Response to Planning application from Hertfordshire County Council (T and CP GDP Order 2015)

District ref: 6/2021/0801/HOUSE
HCC ref: WH/6442/2021
HCC received: 5 April 2021
Area manager: Matthew Armstrong
Case officer: Paul Marshall

8 ORCHID CLOSE HATFIELD AL10 9FE

Installation of front window to facilitate conversion of garage into a habitable room

PROPOSED SITE LAYOUT (AS BUILT)
SCALE 1:200

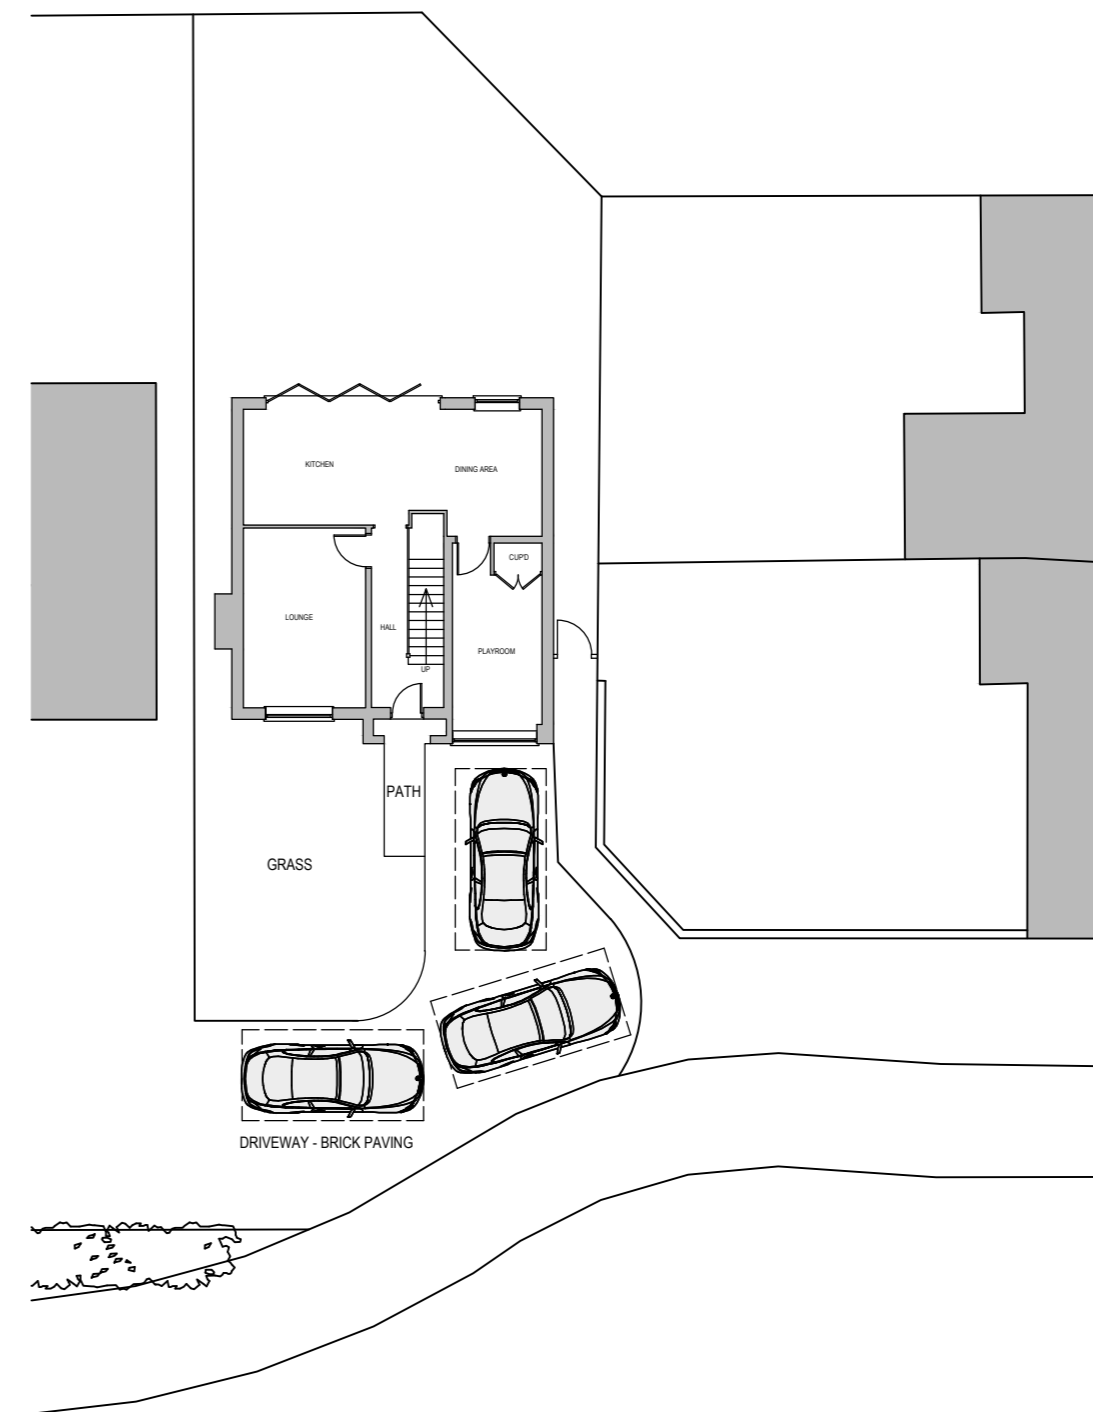
The loss of a garage space would not impact the surrounding highway network in terms of parking issues. The parking area at the front of the site is adequate to accommodate an extra parked vehicle
